Application for Removal or Variation of a Condition following Grant of Planning Permission or Listed Building Consent

Number	5
Suffix	
Property Name	
Address Line 1	Woodsome Drive
Address Line 2	Fenay Bridge
Address Line 3	Kirklees
Town/city	Huddersfield
Postcode	HD8 0JR

ERECTION OF SINGLE STOREY REAR, TWO STOREY SIDE AND TWO STOREY
FRONT EXTENSIONS

2024/62/91084/W

title
Elevations - As Proposed

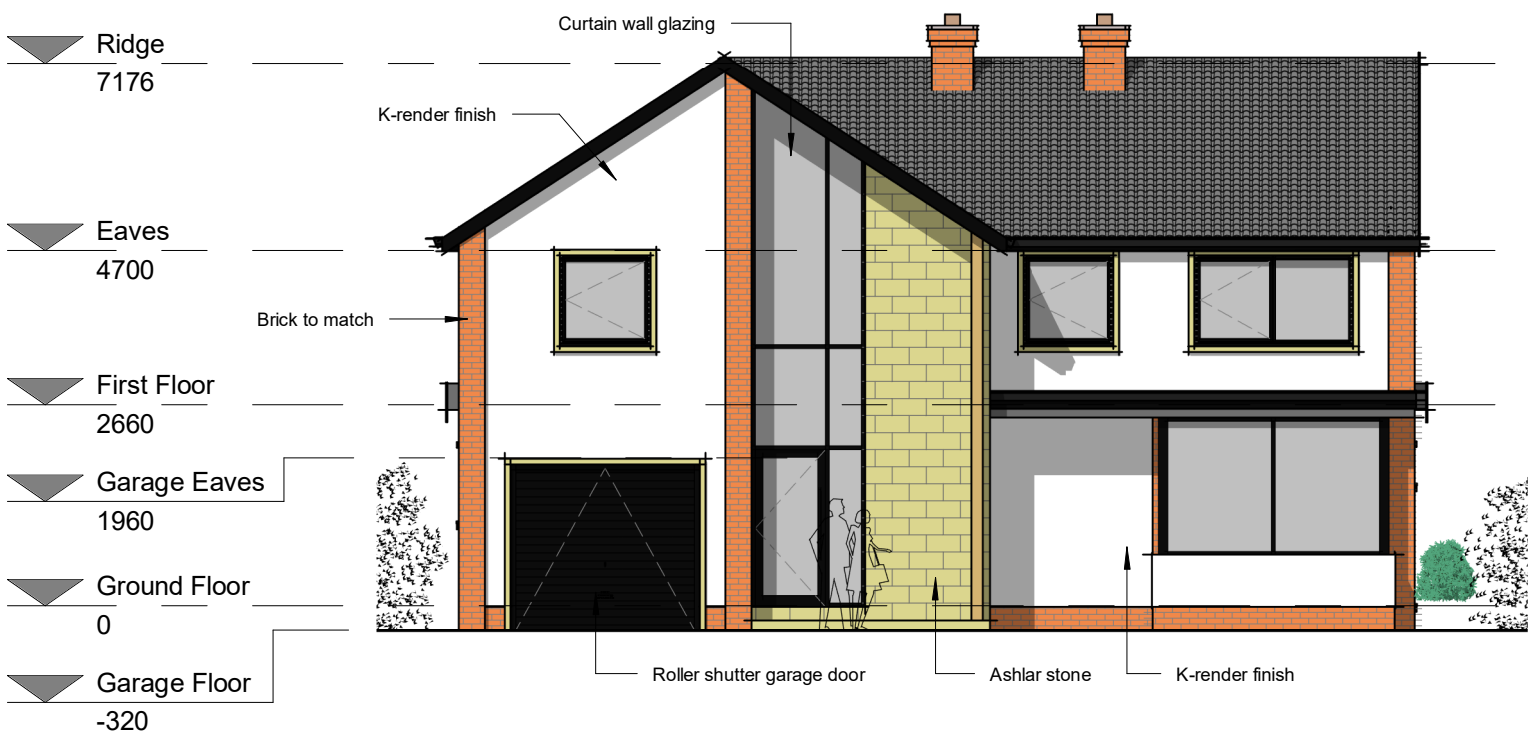
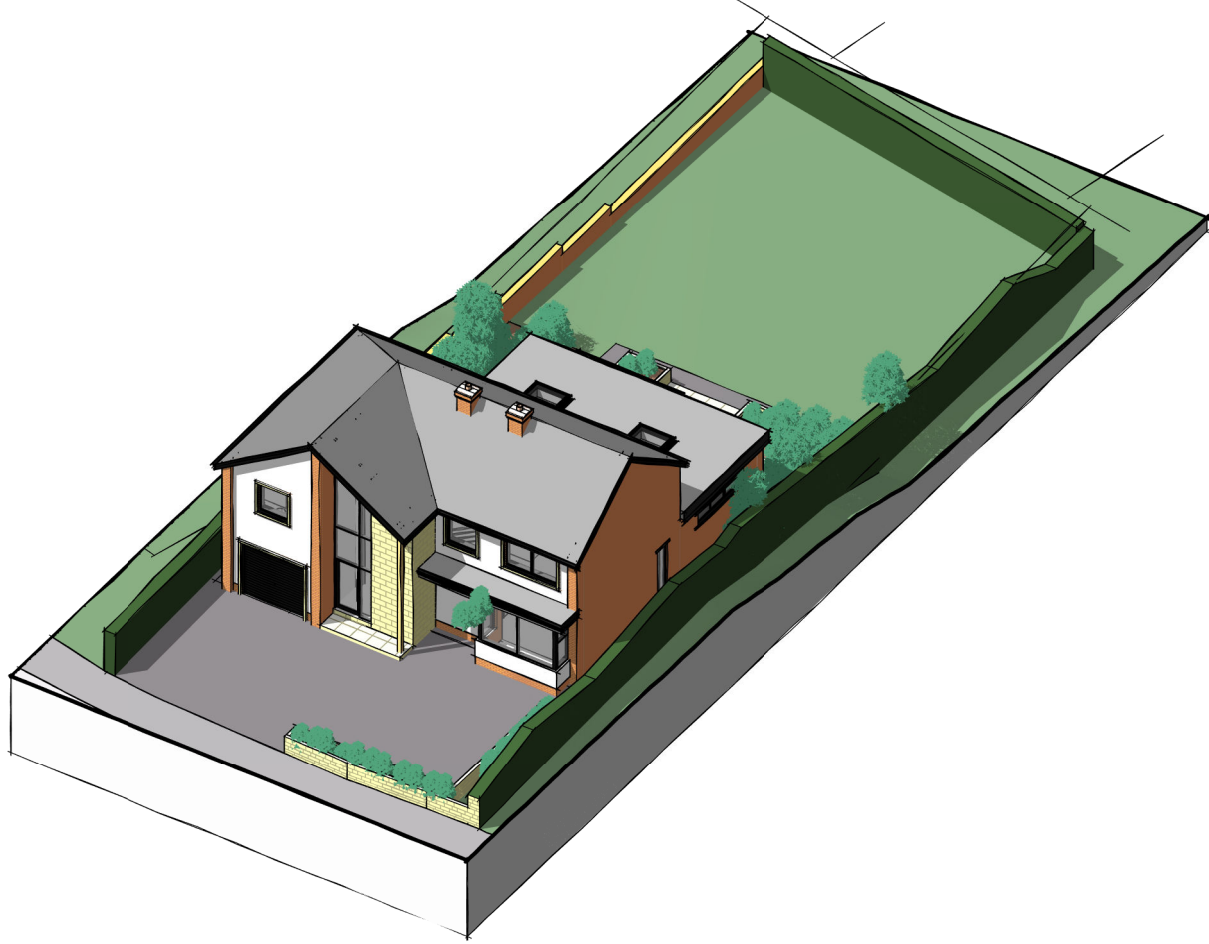
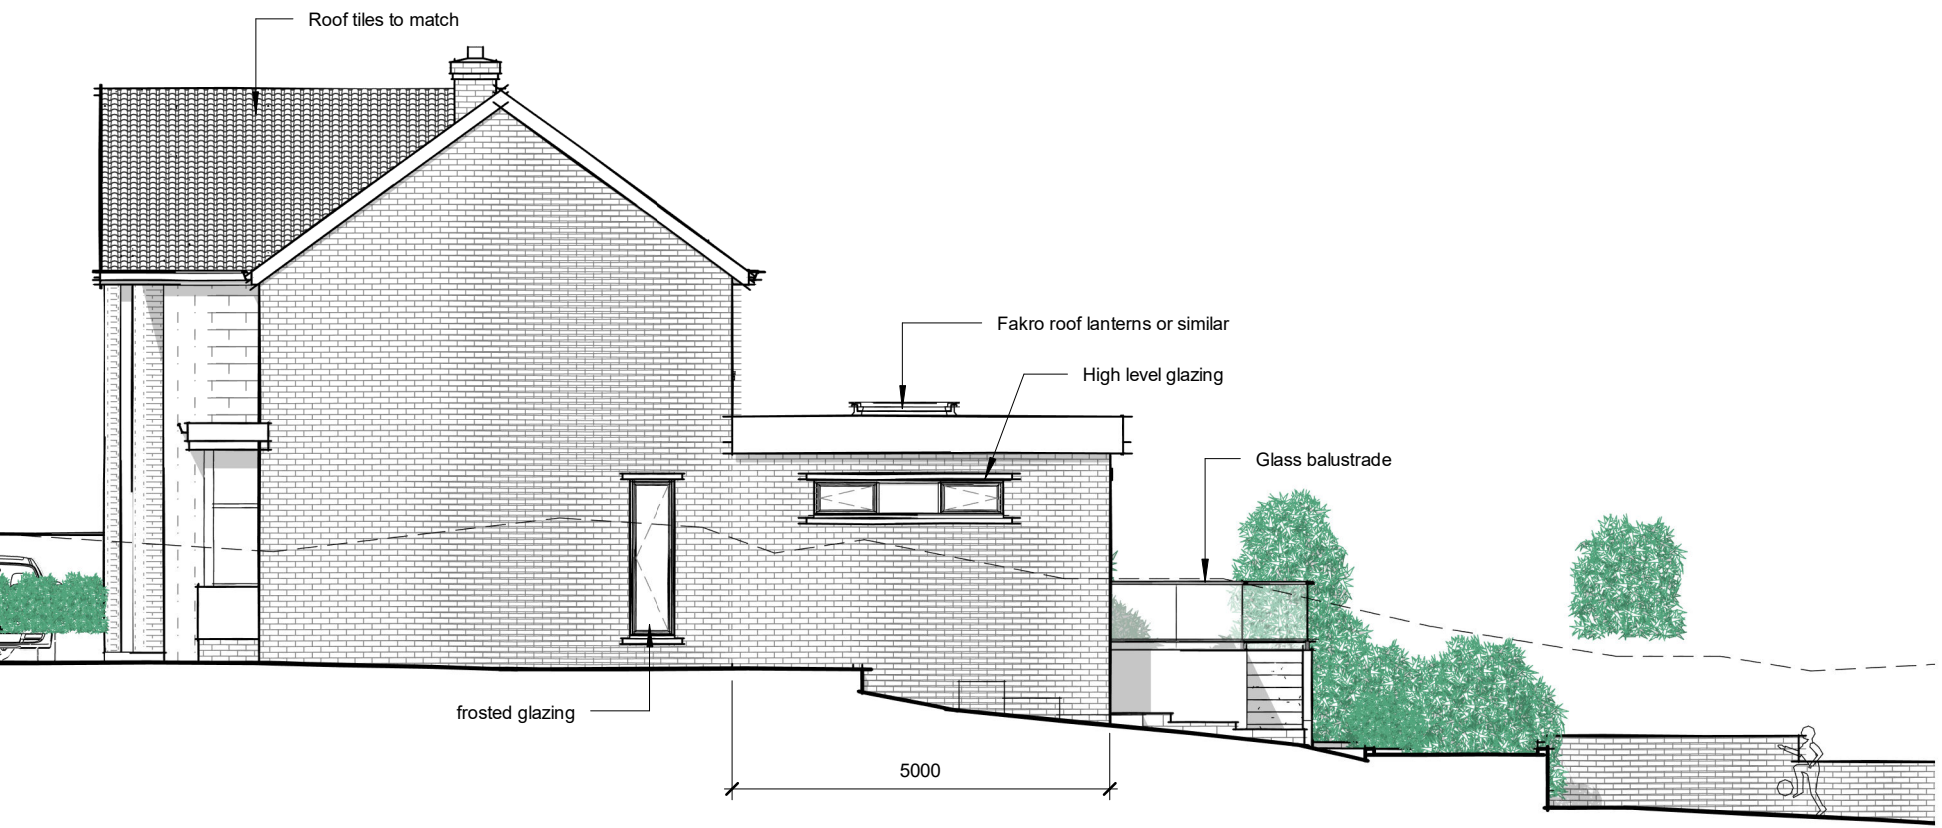
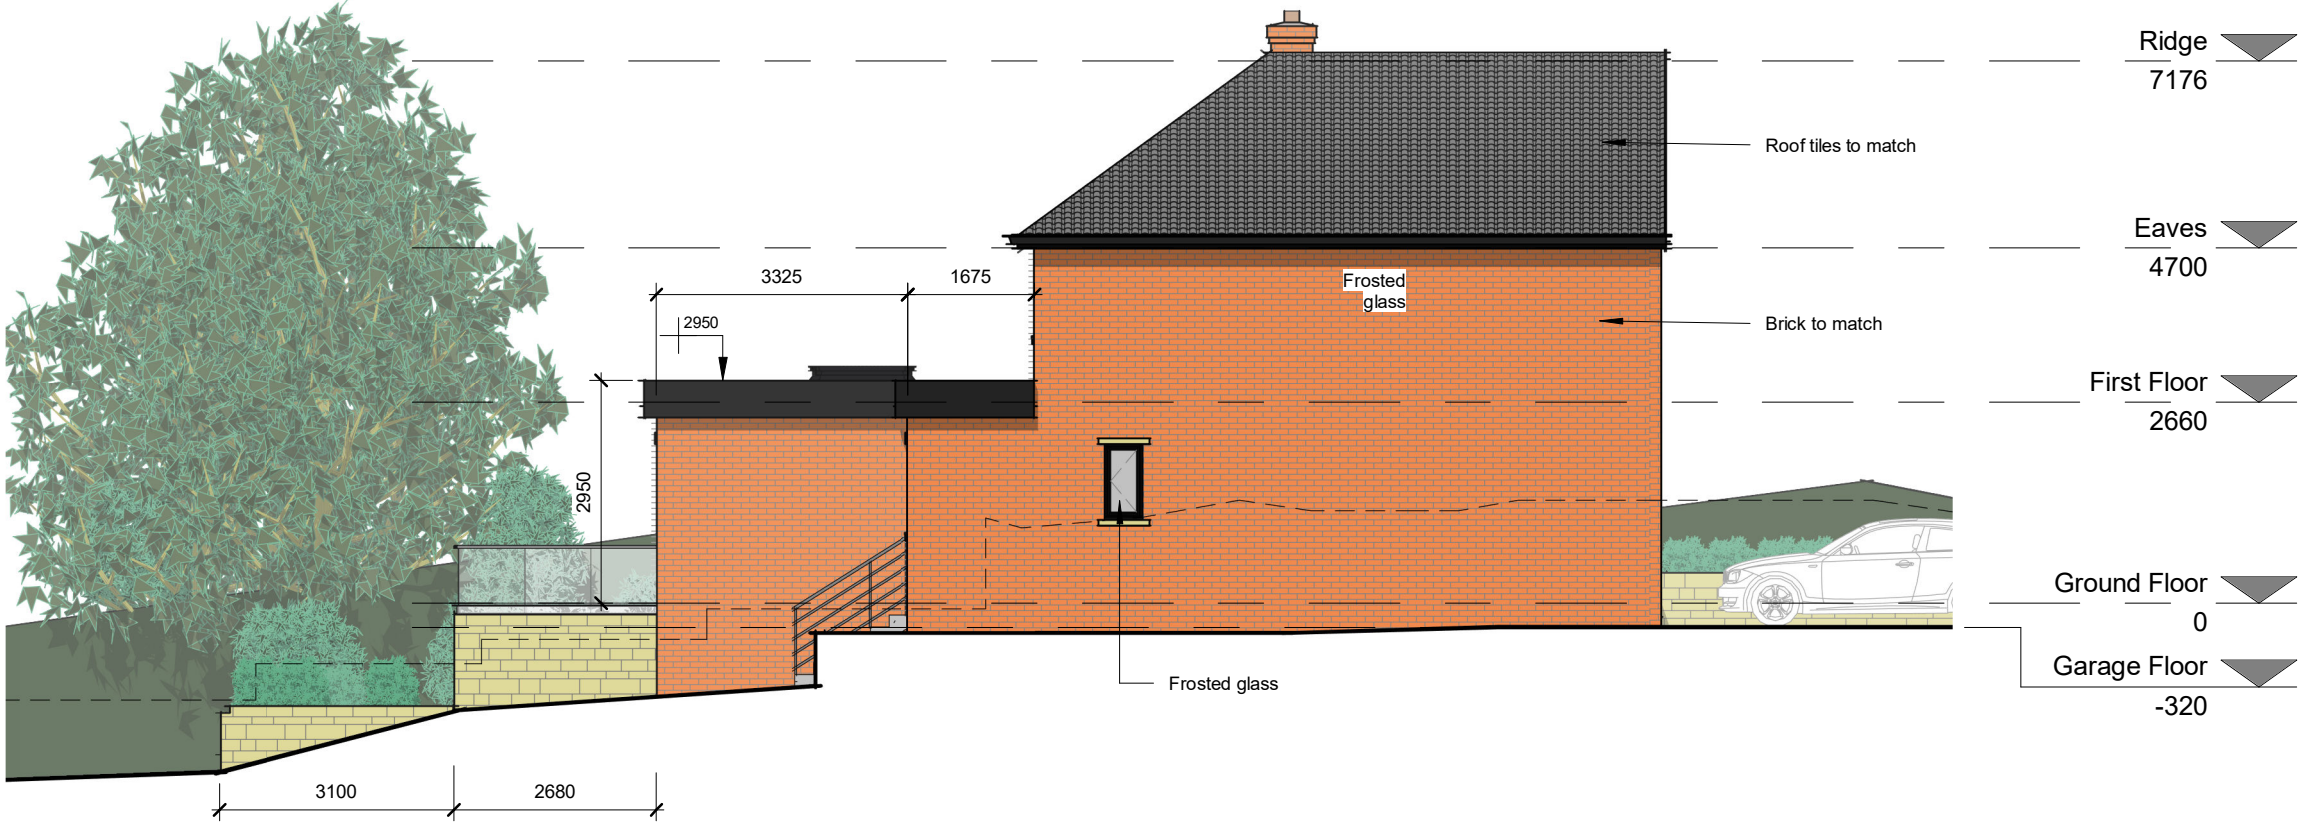
rear extension increased in width and door positions amended
first floor layout amended
front first floor window amended
rear first floor windows added

varied to accept minor changes as listed above and shown on updated submitted drawings
